Department for Transport

21 July 2020

PLANNING ACT 2008: APPLICATION FOR THE PROPOSED A303 SPARKFORD TO IILCHESTER DUALLING ORDER

FIGURE 2.5  
HAZLEGROVE JUNCTION UNDERBRIDGE  
GENERAL ARRANGEMENT

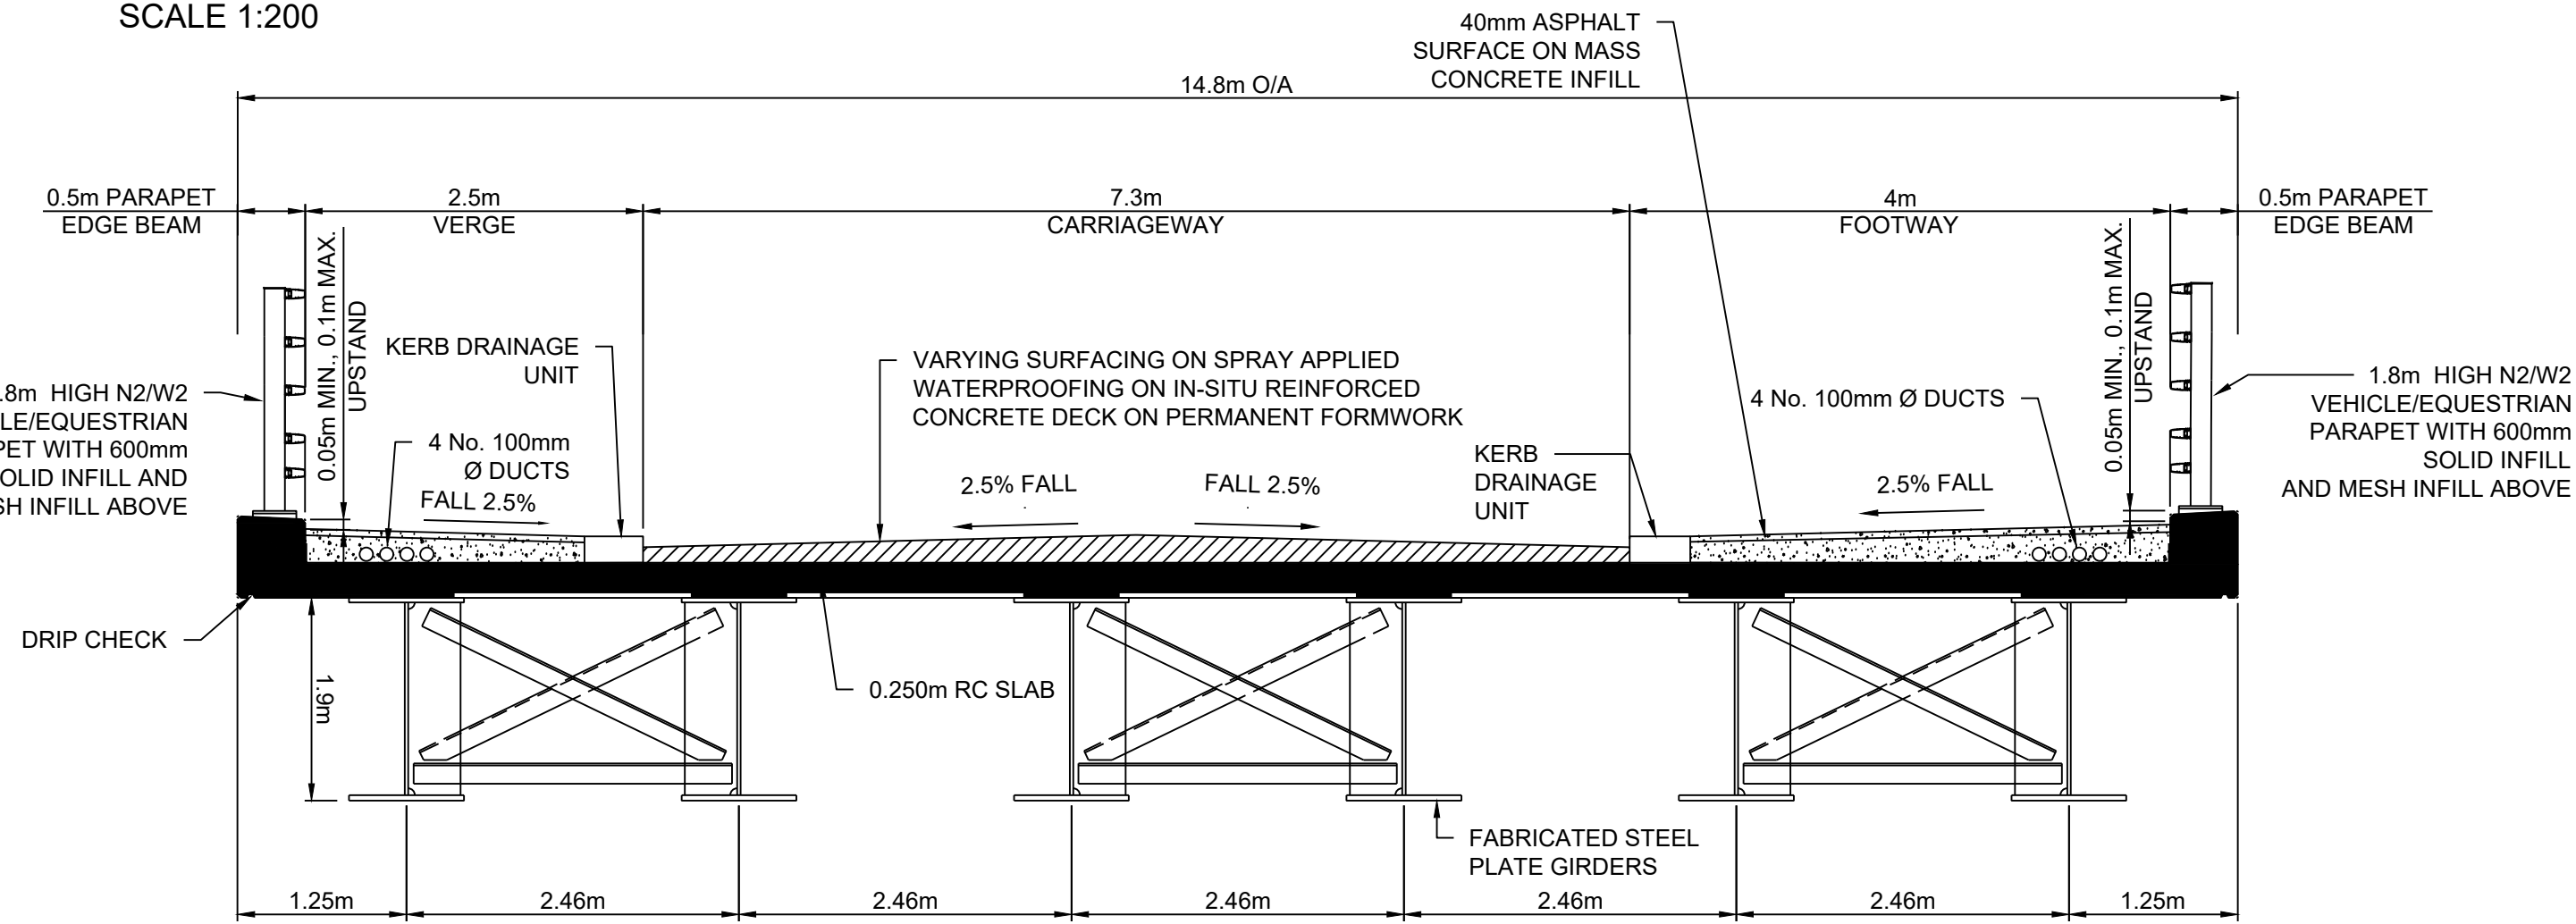
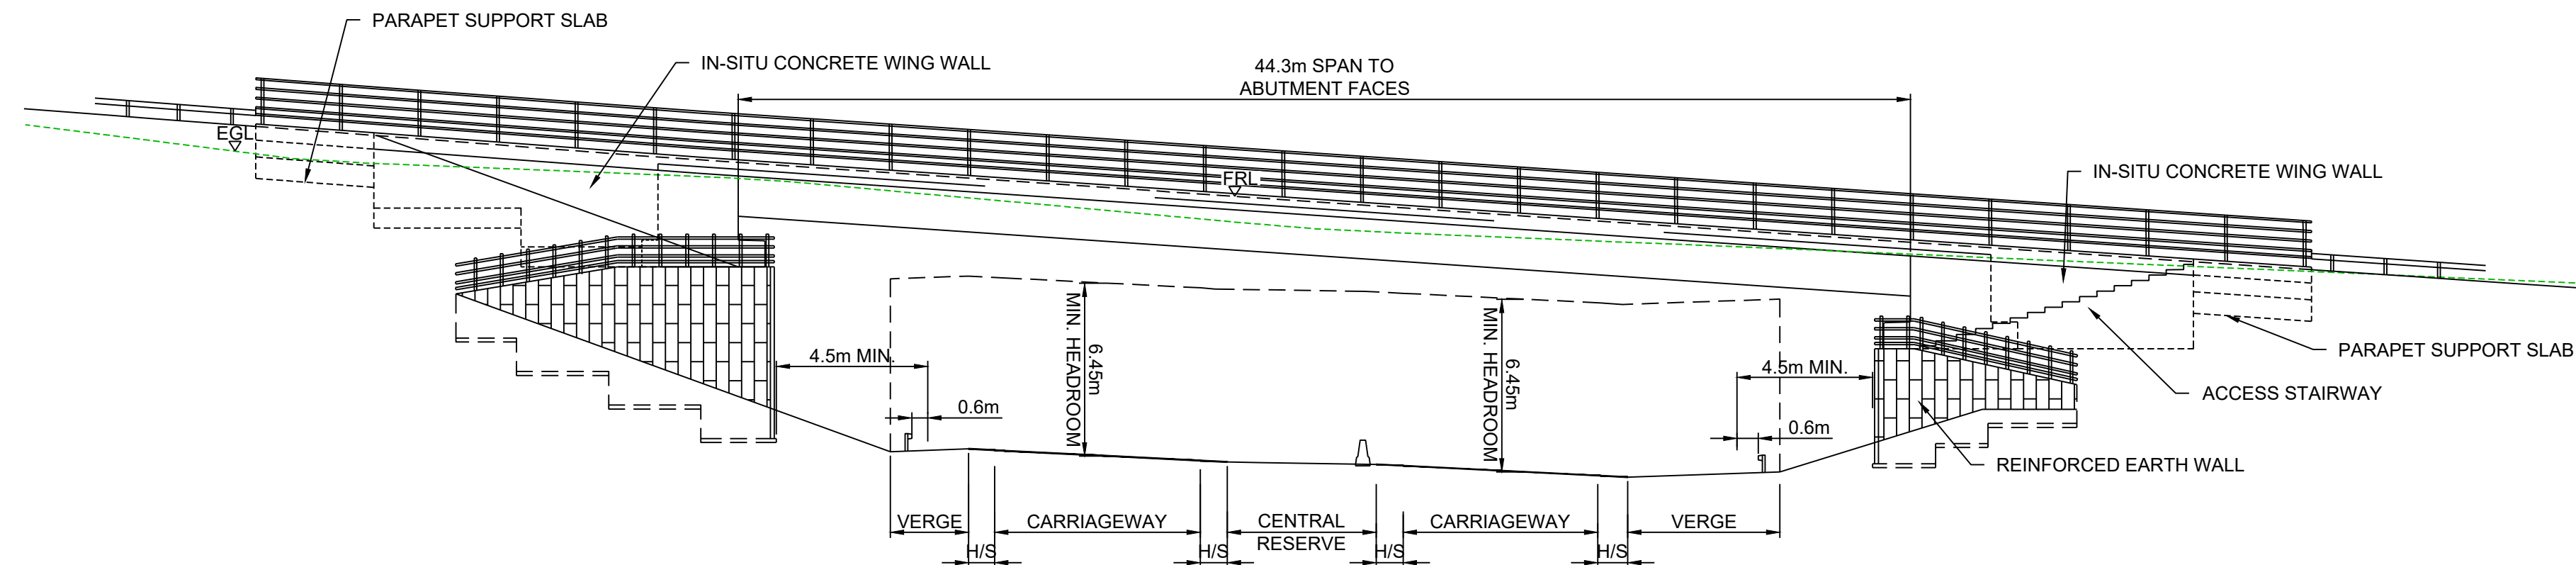
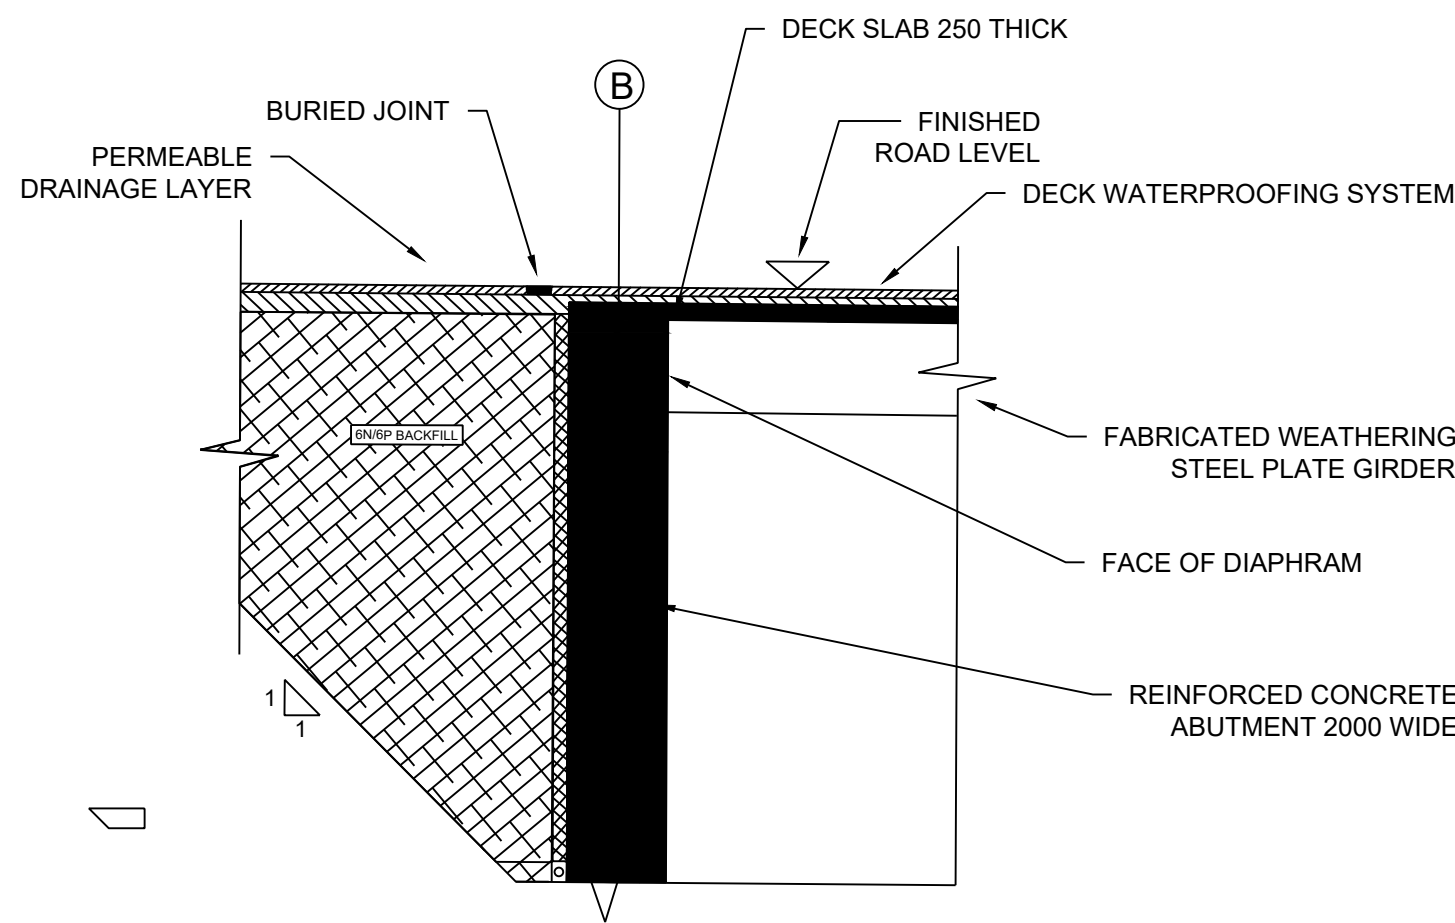
27. The Secretary of State notes that the importance of the Hazlegrove underbridge to the NMU network is explained in ES Chapter 12 which would provide the primary crossing point for NMUs towards the eastern end of the Proposed Development. The Secretary of State notes that it is proposed that the underbridge would be used for motorised and non-motorised traffic and only lit during the daytime. The Secretary of State notes that the ExA questioned the safety implications of not providing lighting during the hours of darkness; the Applicant indicated that no specific security assessment of the underbridge or its approaches has been undertaken with respect to the provision of lighting for the NMU route (ER 10.5.58 to 10.5.60).

28. The Secretary of State notes that the ExA considers in the absence of lighting the underbridge would not provide an attractive route for NMUs and as a consequence fails to accord with paragraph 5.184 of NNNPS (ER 10.5.61). The ExA therefore recommended a new paragraph (2) to requirement 16 for the scheme to include measures for lighting the Hazlegrove junction underbridge during hours of darkness (ER 16.6.154 Table 9).

29. The Secretary of State is minded to agree that night-time lighting represents a reasonable step that is essential to minimise the risk of road casualties and improve road safety (ER 10.5.75) and would be minded to agree with the ExA's recommended change to the DCO. However, he considers that he does not have sufficient information to determine whether such a requirement would be deliverable and seeks information from the Applicant as to whether the required mitigation could be delivered.

Appendix 2 POTENTIAL LEGACY ISSUES IF ONLY PARTIAL REVOCATION OF 1996 SRO

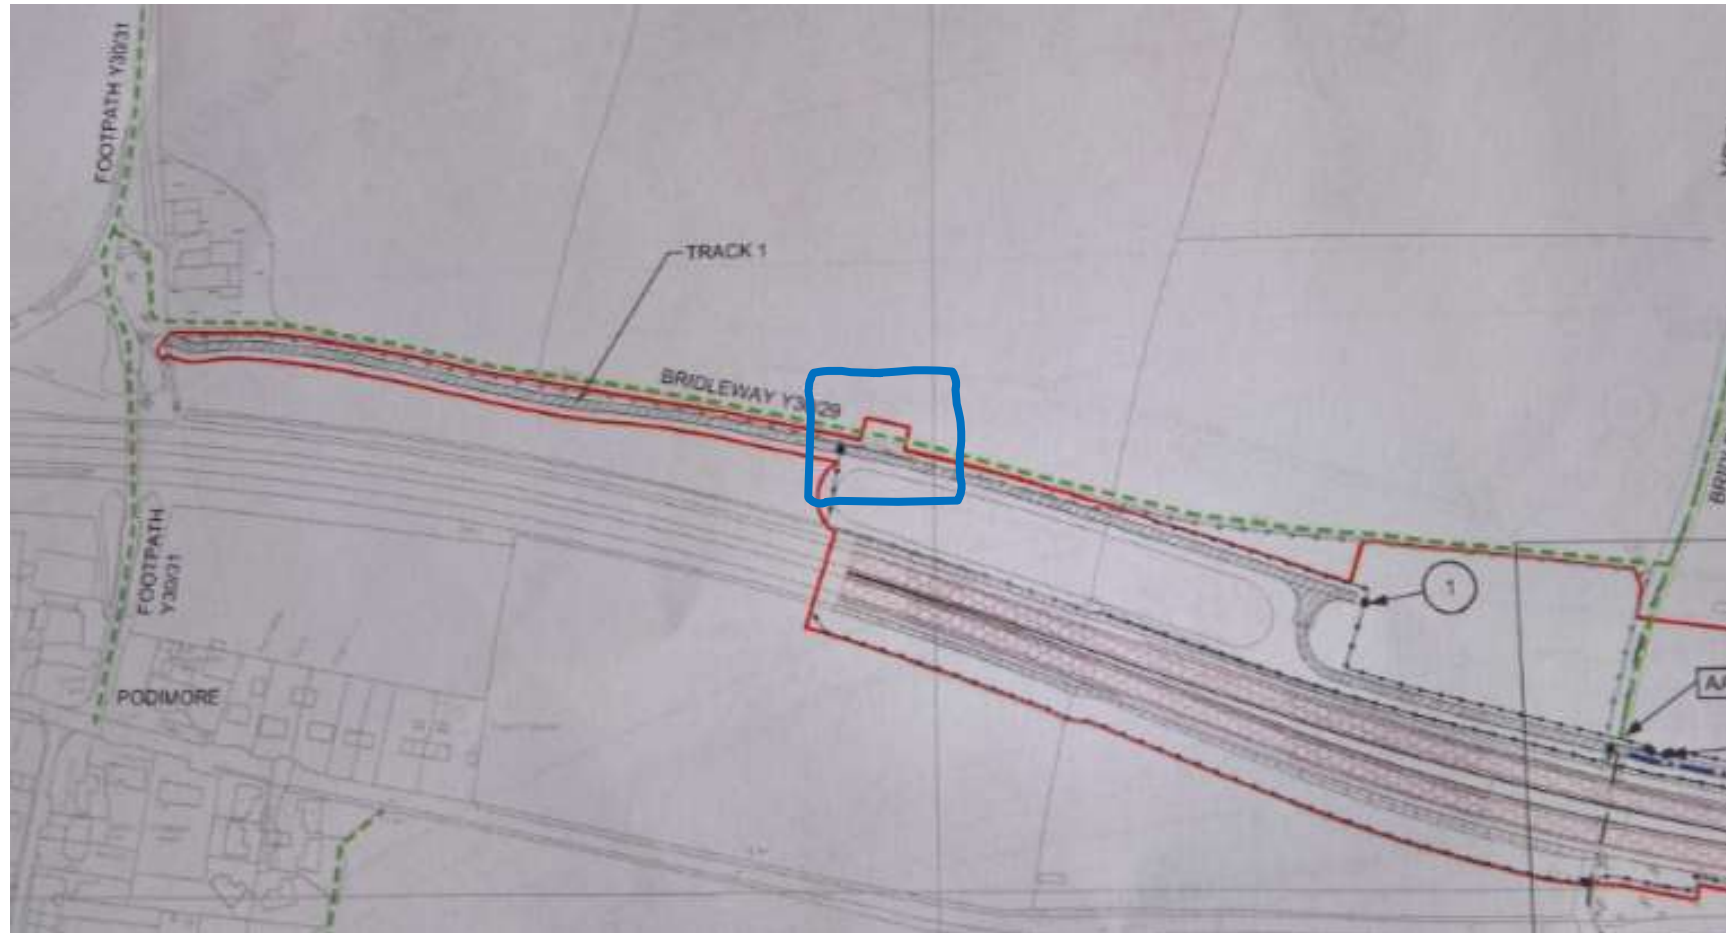
17. The Secretary of State notes the debate in the examination regarding the status of bridleway Y30/29, which was authorised as part of the Side Roads Order that came into effect on 7 November 1996 and authorised the provision of a bridleway connecting Eastmead Lane with High Farm Lane (ER 10.5.28 and 10.5.29). The Secretary of State notes that in the absence of any evidence to suggest that Somerset County Council (“SCC”) was notified that bridleway Y30/29 was complete and open to traffic (ER 10.5.30), the ExA concludes that the bridleway was not delivered as part of the 1996 Side Roads Order. The Secretary of State notes that the ExA concludes that bridleway Y30/29 has no legal status and accordingly there is no connection for walkers, horse-riders or cyclists via Y30/31 between Podimore and Y30/28 (ER 10.5.33 and 10.5.35).

20. The Secretary of State notes the alternative proposed by SCC, South Somerset District Council and South Somerset Bridleway Association, which would follow bridleway Y30/29 until it reached bridleway Y30/UN at Higher Farm Lane, where the existing Higher Farm Bridge could be used to cross the A303 into the village of Podimore. This diversion would be about 1.5km in length. The Secretary of State notes that this route would require Y30/UN to be upgraded from footpath to bridleway status (ER 10.5.36) and potentially alterations to Higher Farm Lane Bridge. The ExA concluded that an additional requirement should be included in the DCO to ensure that adequate mitigation is provided (ER 10.5.46).

22. The Secretary of State is minded to agree with the ExA's concern that mitigation for this impact is required and would therefore be minded to agree to the inclusion of the ExA's suggested requirement were he to grant development consent. However, the Secretary of State does not currently have enough information before him to determine whether the requirement proposed by the ExA would be deliverable and seeks information from the Applicant as to whether appropriate mitigation could be delivered.
